RE: Submission regarding Gregory Place Build-to-Rent State Significant Development (SSD).

This letter has been prepared by Mecone on behalf of the Trustees of the Roman Catholic Church for the Diocese of Saint Maron, Sydney also known as the Maronite Catholic Eparchy of Australia, New Zealand and Oceania (Maronite) to provide feedback on the SSD application (SSD-31179510) for proposed concept affordable housing and build-to-rent development at 2A Gregory Place, Harris Park (development site).

2 Concept Envelope Plan - Stanisic Architects

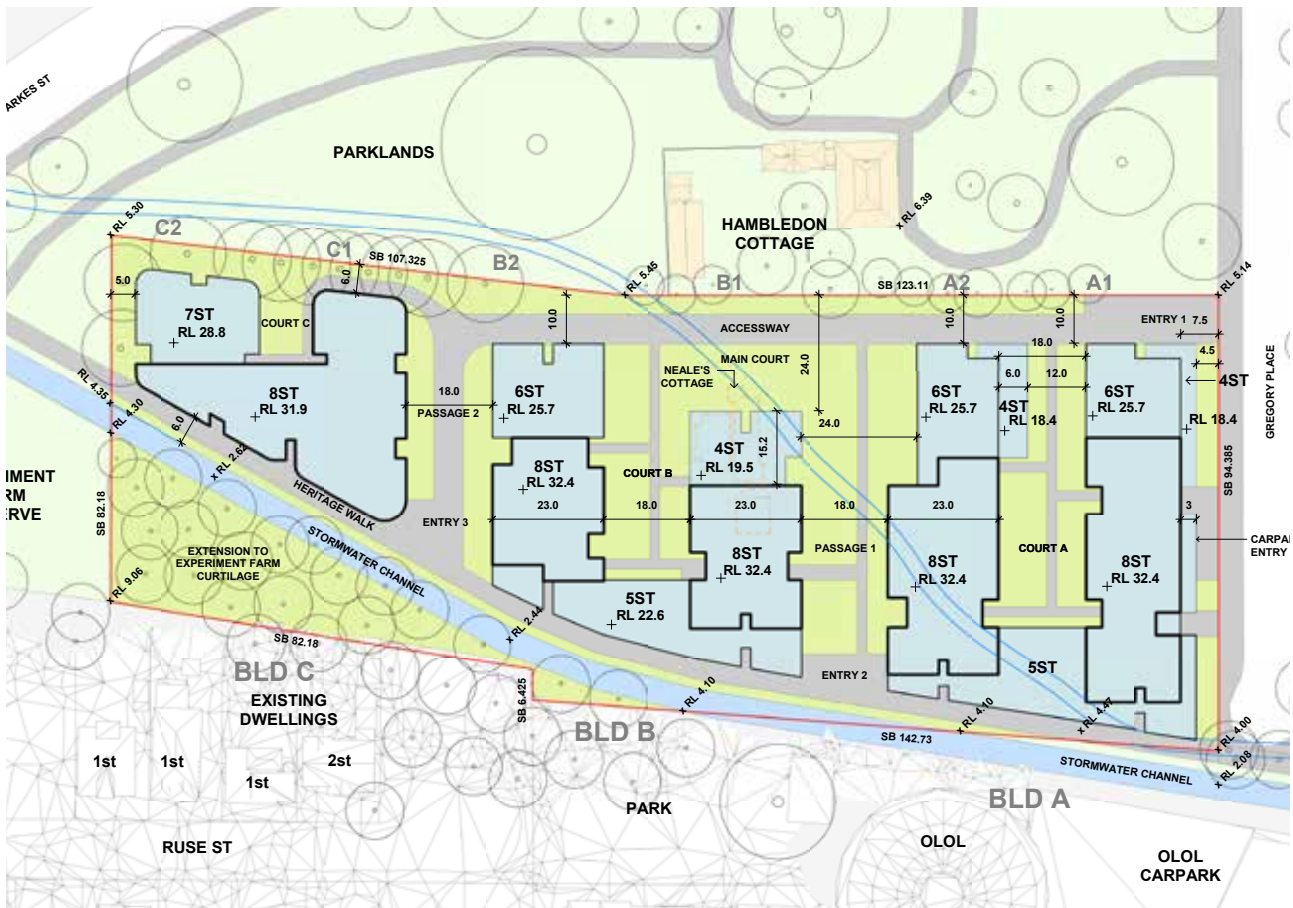
The design of the buildings aims to minimise the bulk located at the north of the development site at the interface with the Hambledon Cottages (State heritage item at 47 Hassall Street,

Harris Park) to be sympathetic to heritage values. However, this has meant additional massing located at the south of the site which directly impacts the submission site.

As noted previously, most of the bulk of the proposed development is located on the south which directly impacts OLLC the most.

The design of the development has considered impacts of bulk and scale on the Hambledon Cottage located north of development site and the closest heritage item to the site. However, this comes at the expense of southern properties with the proposed bulk and scale concentrated at the southern boundary of the development site, impacting the OLLC.

Key public viewing points - Proposal

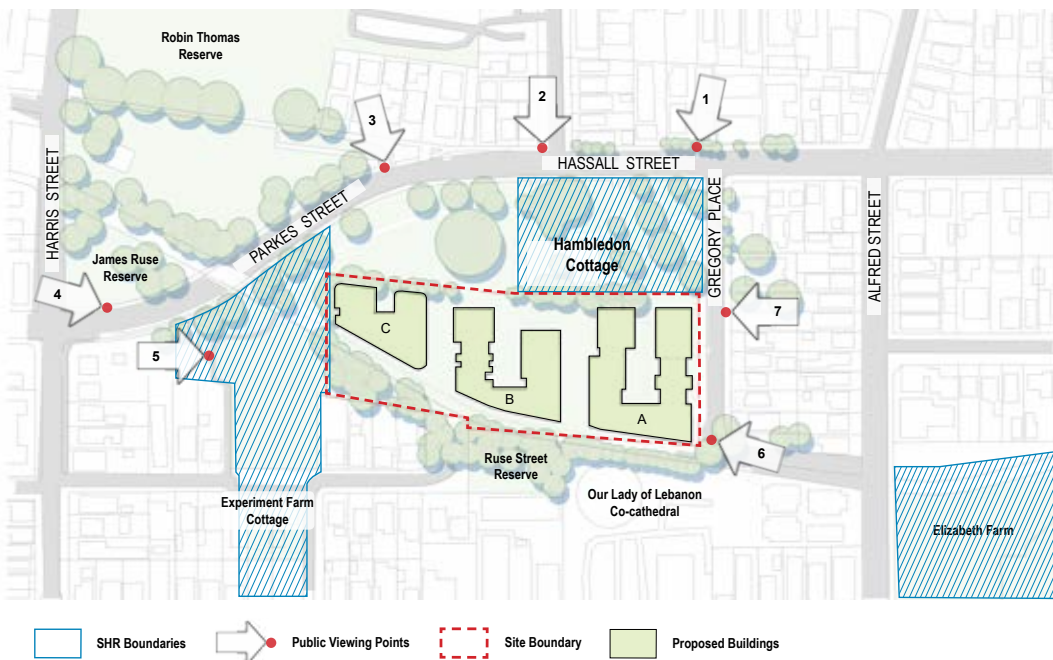
The development is anticipated to reduce the views of the submission site to State Heritage Register (SHR) listed site at Experiment Farm Reserve (to northwest of OLLC), SHR heritage item at Hambledon Cottage Reserve (north of OLLC), Robin Thomas Reserve and James Ruse Reserve (northwest of OLLC).

The excessive height and bulk of the development also blocks the visibility of the submission site from these northern open spaces which detracts from the prominence of the cathedral building in the skyline.
